Sylvania Affordable Housing (SSD-83258708) Response to Request for Additional Information

Thank you for the request for additional information in relation to the assessment of the Sylvania Affordable Housing project (SSD-83258708) at 29 Florida Street, Sylvania.

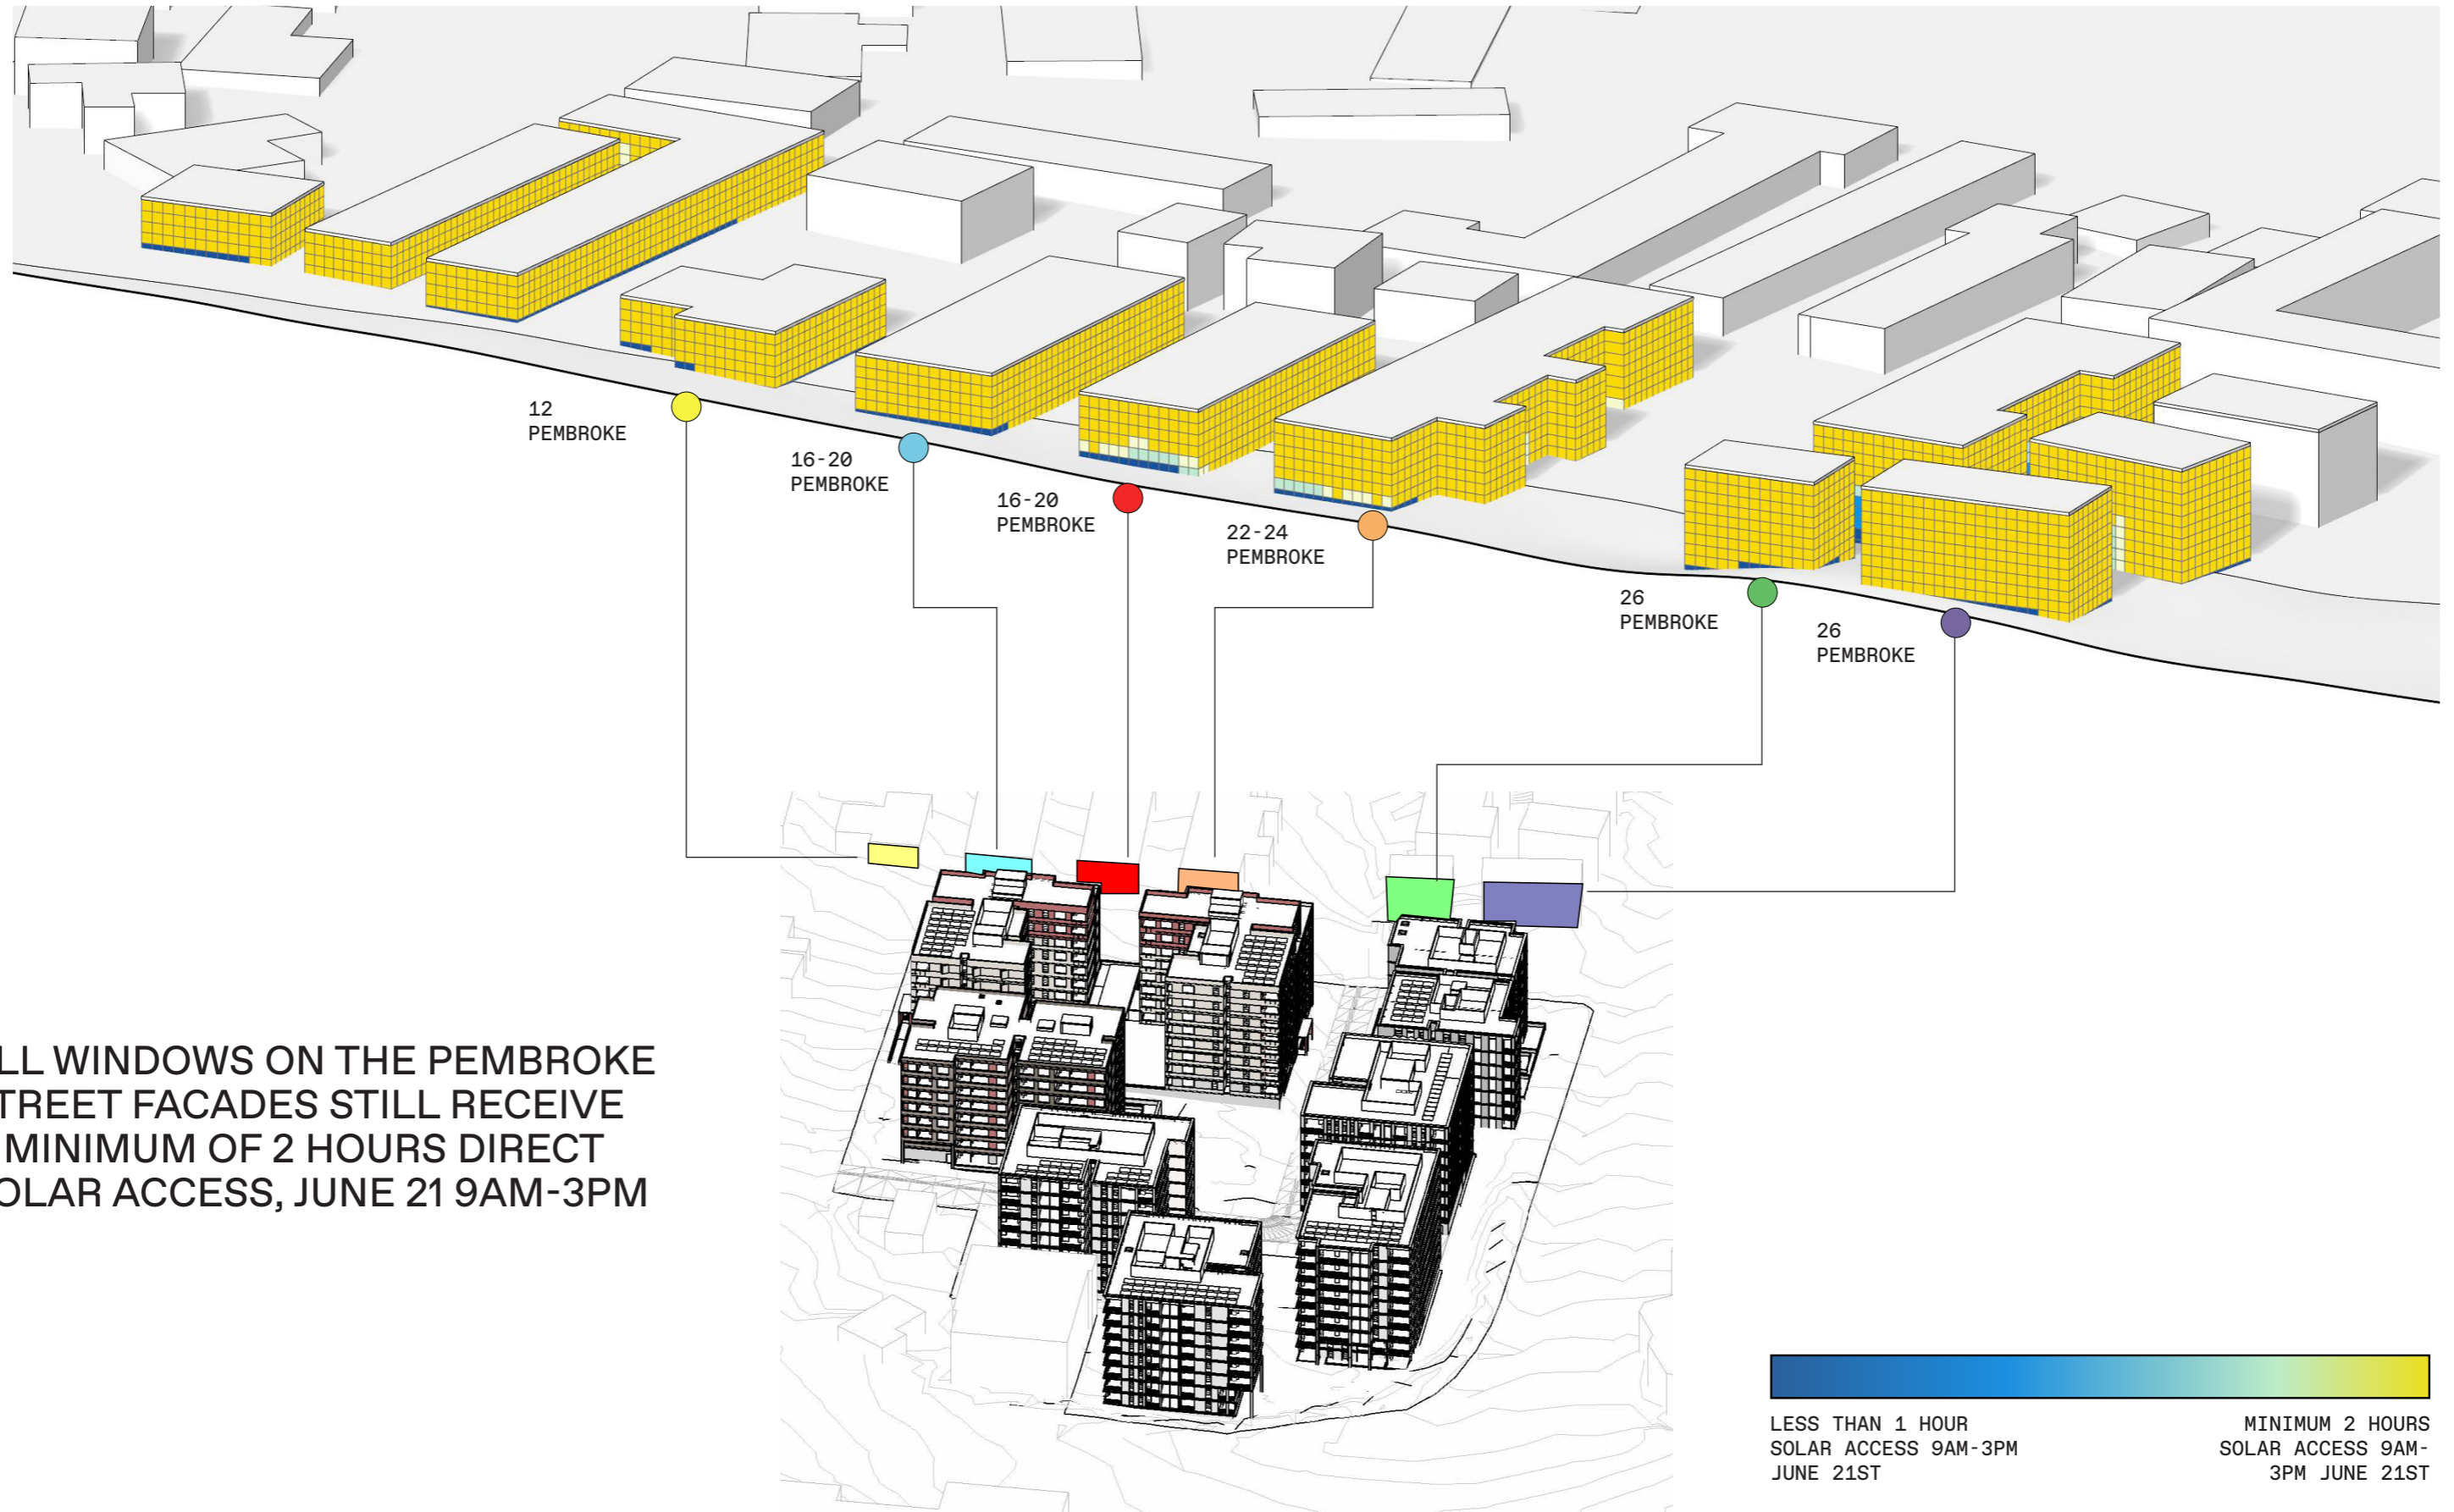
The diagrams provided acknowledge that all north facing windows to the habitable rooms of 12 to 26 Pembroke Street currently enjoy in excess of 5 hours of solar access between 9am and 3pm midwinter. The current proposal reduces solar access to habitable windows of 16-20 and 26 Pembroke Street below 2 hours (between 9am and 3pm mid-winter). The applicant also provides a solar study showing the impact of a height compliant building. This study demonstrates that 16-20 and 26 Pembroke Street would receive in excess of 2 hours solar access, but 26 Pembroke Street would still receive less than 2 hours solar access.

<u>Summary</u> The diagrams provided demonstrate that the noncompliant height will reduce solar access to the habitable windows of 16 to 20 Pembroke Street to less than 2 hours, whereas a height compliant would maintain 2 hours of solar access to the habitable windows. The impact of the noncompliant height upon POS and COS is negligible. Furthermore, height controls provide a maximum height, and good design practice should seek to redistribute the height across the site to minimise overshadowing of the southern neighbours. As previously recommended, the solar study should be used as a tool to further refine the distribution of building form across the site.	As confirmed in the solar analysis by BVN (submitted as part of the previous RFI), the minor overshadowing impact is limited to one of nine townhouses, with the remaining eight townhouses at 16-20 Pembroke Street all continuing to achieve a minimum of two hours solar access to the primary living areas and private open space areas between 9am and 3pm in mid-winter. Accordingly, almost 90% of the townhouses at 16-20 Pembroke Street continue to achieve compliant solar access. Further, if this site were to redevelop under the low and mid-rise controls, there would be no solar impact from the proposed development. Overall, one townhouse would experience a minor reduction in solar access as a result of the proposed development when compared with a

As detailed in the updated overshadowing plans prepared by BVN Architects and updated Clause 4.6 Variation Request provided as part of the previous RFI, the proposed development will maintain a minimum of two hours solar access to most properties along Pembroke Street between 9am and 3pm in mid-winter.

As demonstrated in the analysis by BVN, all living room windows and private open space areas to the properties at 12, 22-24, and 26 Pembroke Street will achieve a minimum of two hours solar access in mid-winter. It is noted the lower parts of these buildings are also screened with fencing and landscaping further reducing any overshadowing impacts from the proposed development, and the buildings are typically

height-compliant scheme. Having regard to the site orientation and topography, required flood planning levels, delivery of social and affordable housing, and the design measures adopted to minimise overshadowing, the limited impact is considered acceptable.

GA - OVERALL - LEVEL 04

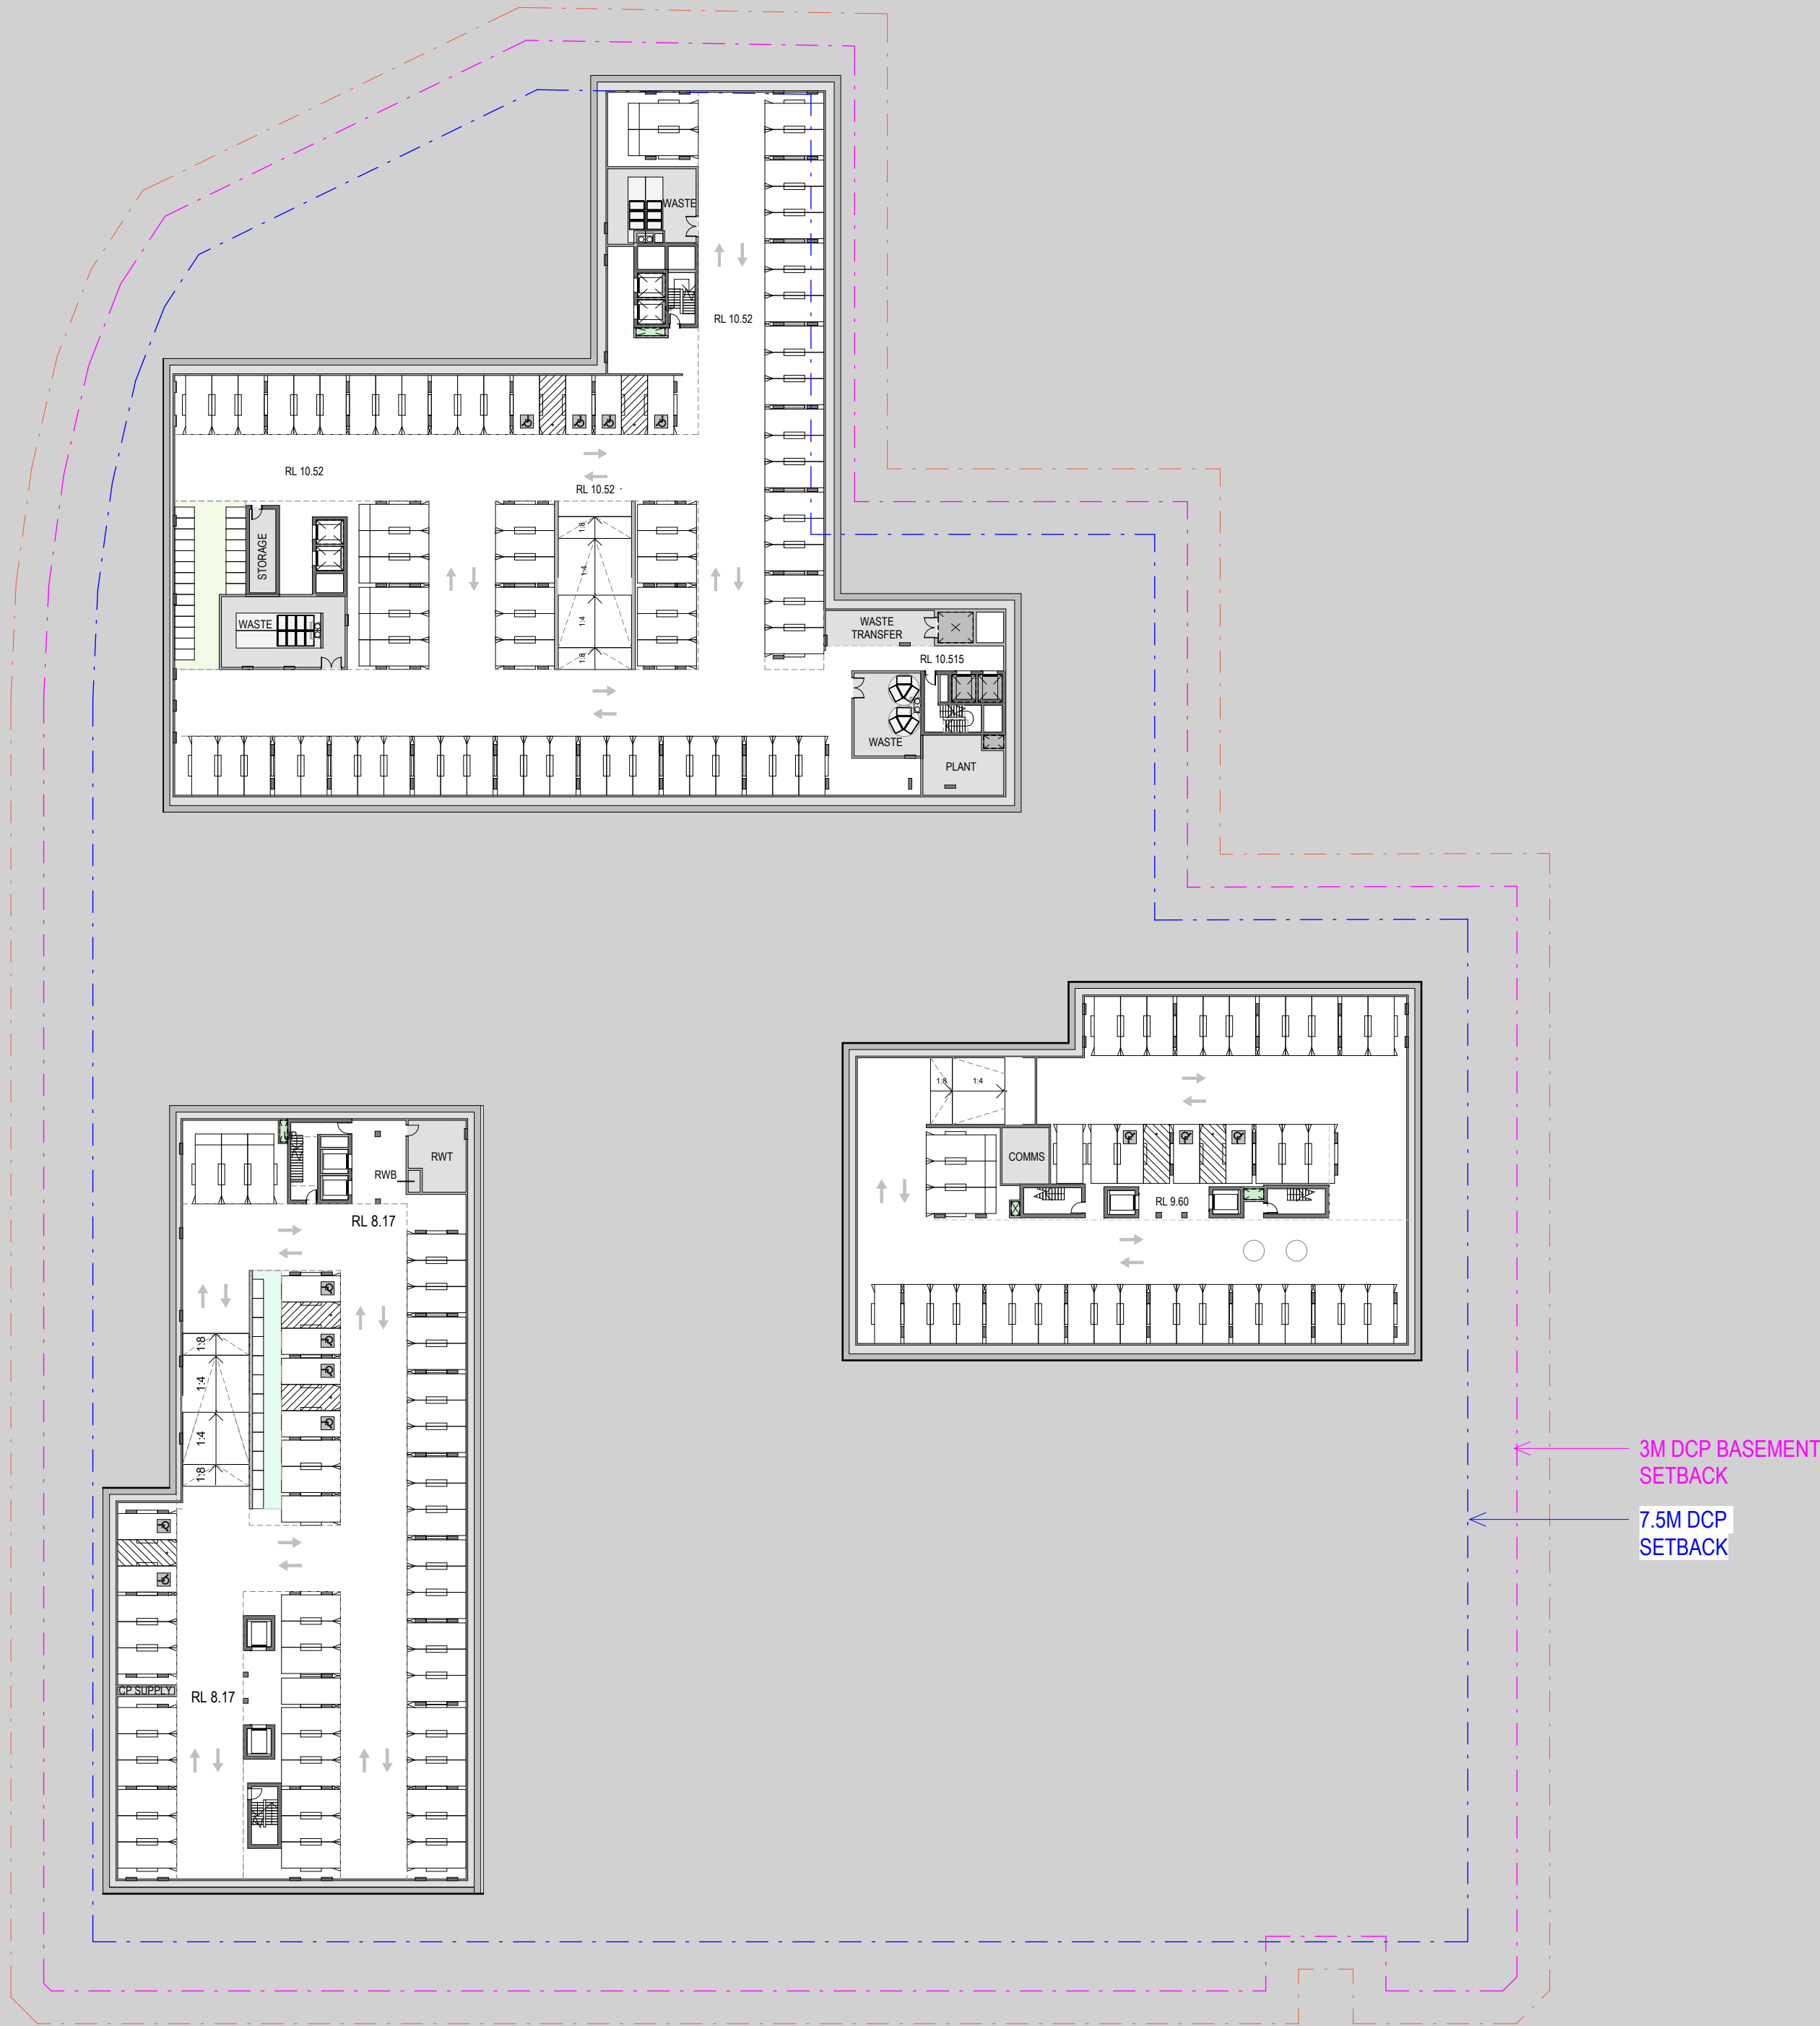
At this meeting, Council staff requested further refinements to the waste servicing arrangements for the social housing building to improve manoeuvring for Council's waste collection vehicle. These minor refinements have been incorporated into the revised Architectural Plans at Attachment A (refer to Drawing ref: GA - Overall - Level 04).
